Add PCD Project #
AL 21-015

April 16, 2021

**RE: Venetucci Farm / Traffic Generation and
El Paso County, Colorado**

Overall site-generated trip distribution patterns and assignments are shown on Figure 3. Projected Year 2022 total traffic volumes and intersection geometries are also shown on Figure 3.

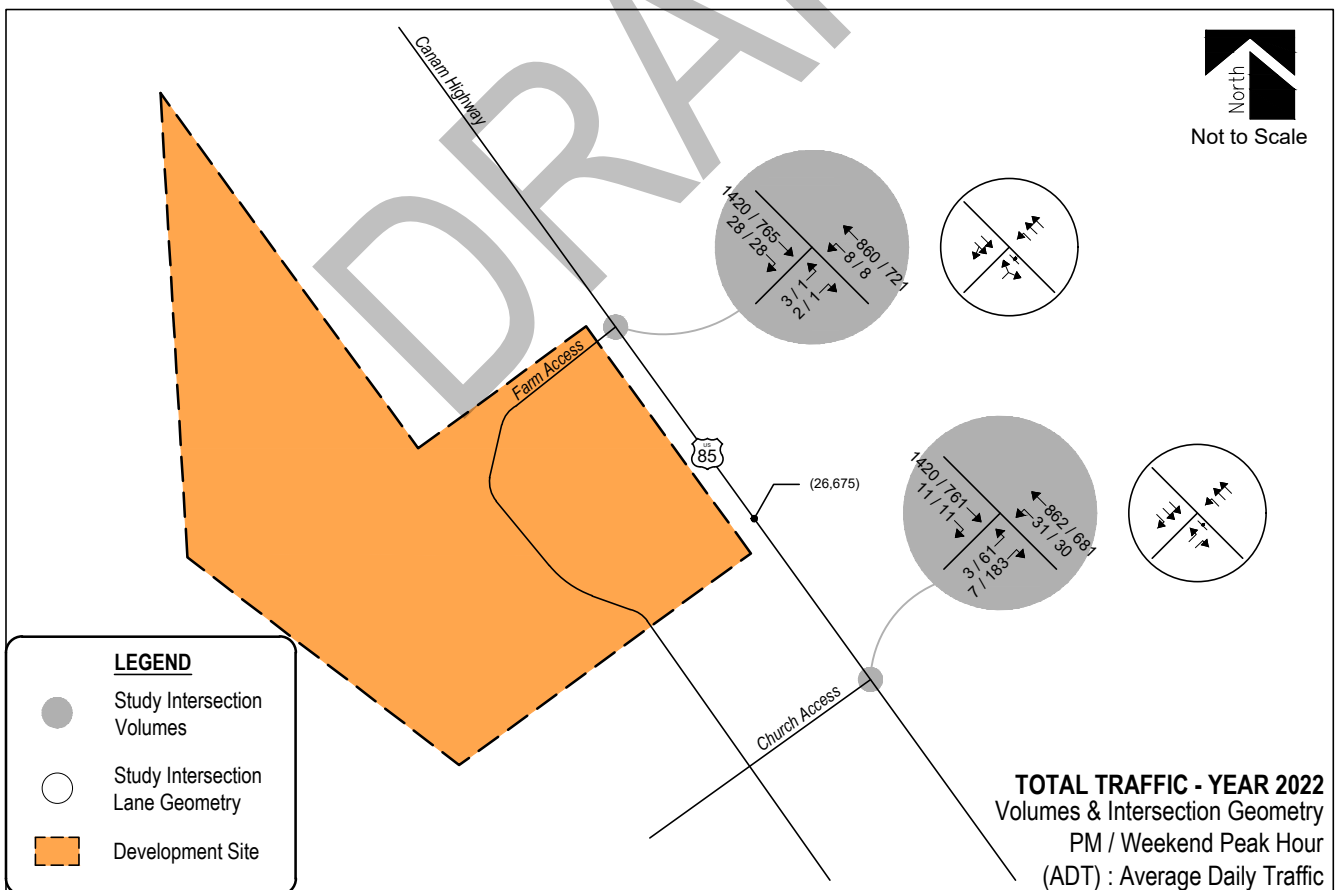
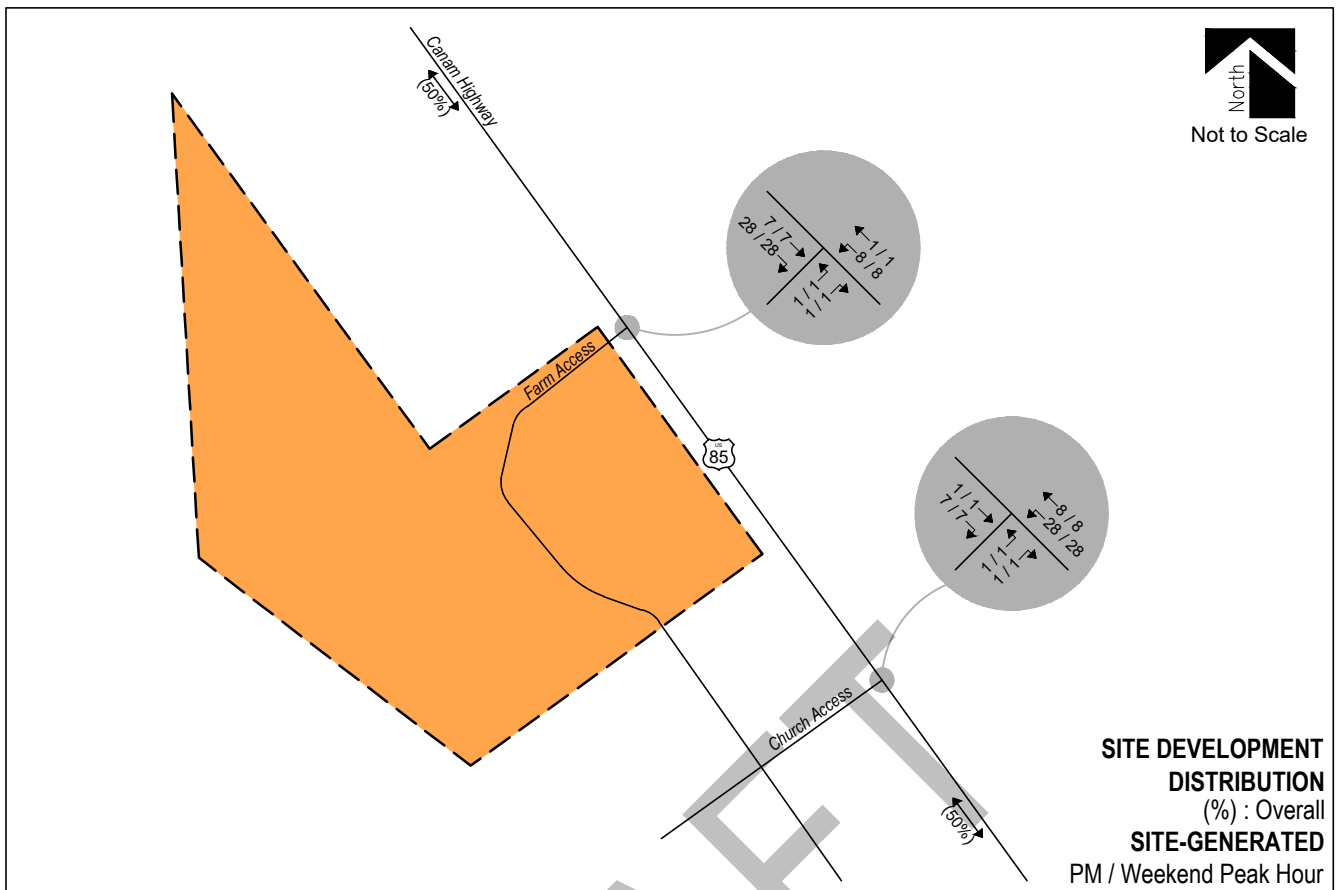
Discuss traffic impacts in the event the wedding venue occurs at the same time as church services on Sundays. It seems a worse-case scenario is having both church service and guest for the wedding venue arriving at the same time.

Text updated to provide additional detail of potential overlap scenarios. Note that with the exclusion of the Church Access from the current site plan, traffic impacts caused by overlapping peak periods of operation are expected to be minor.
